To: Development Review, El Paso County
From: Jonathan Bradley, Fire Marshal
Subject: Urban Landing PUDSP
Date: July 31, 2024

CCES Responses

The Monument Fire District has reviewed the PUD development plan for Urban Landing. Based on our initial review of site access, water supply, and fire mitigation, we have the following comments.

V:\130801\URBAN LANDING\EXHIBITS\FIRE TRUCK ACCESS.dwg, 8/29/2024 4:34:46 PM, 1:1

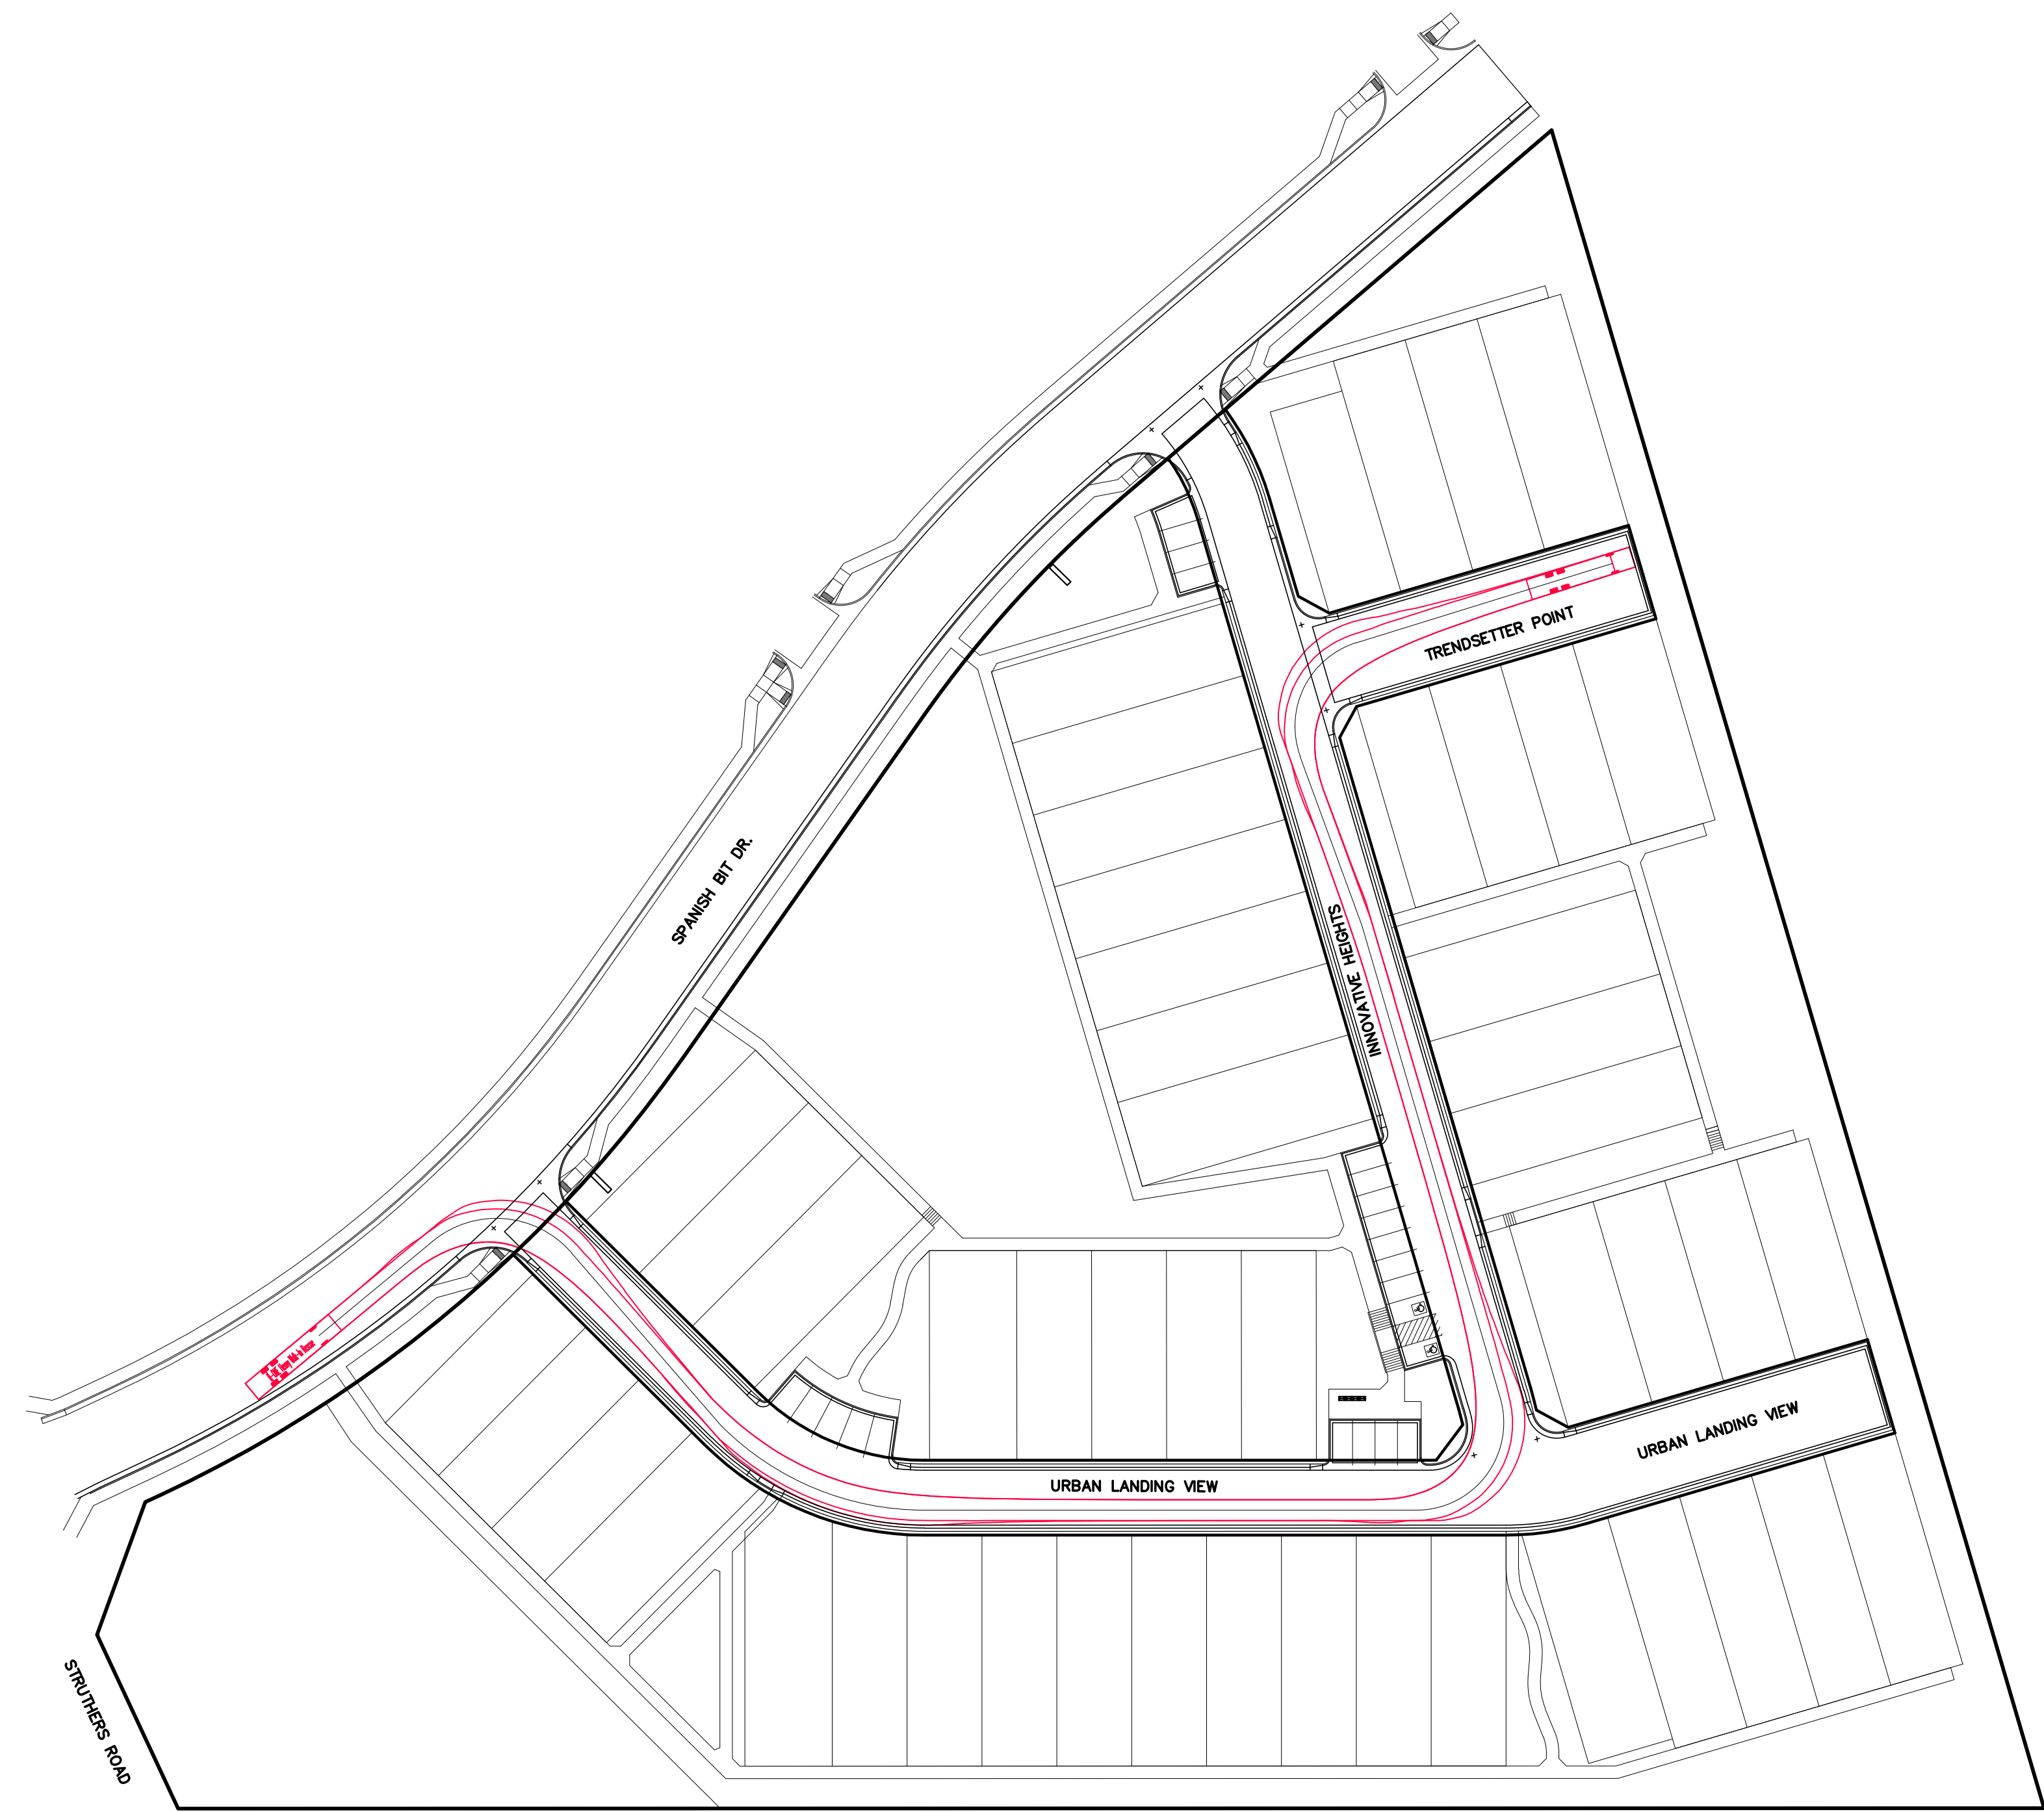
- FD prefers EPC Optional Type C curb and Gutter throughout the development (except designated parking areas) due to narrow roadways to allow large fire apparatus to mount the curb while turning or passing without damaging wheels and tires (see page 3 of 9 in PUD Development Plan). **Revised all areas to be Type C (ramp) curb except for parking, inlet locations and curb returns**
- Evaluate turning radius for attached fire apparatus drawing and determine if proposed roadways will accommodate large vehicle operation. **See attached fire access exhibits**
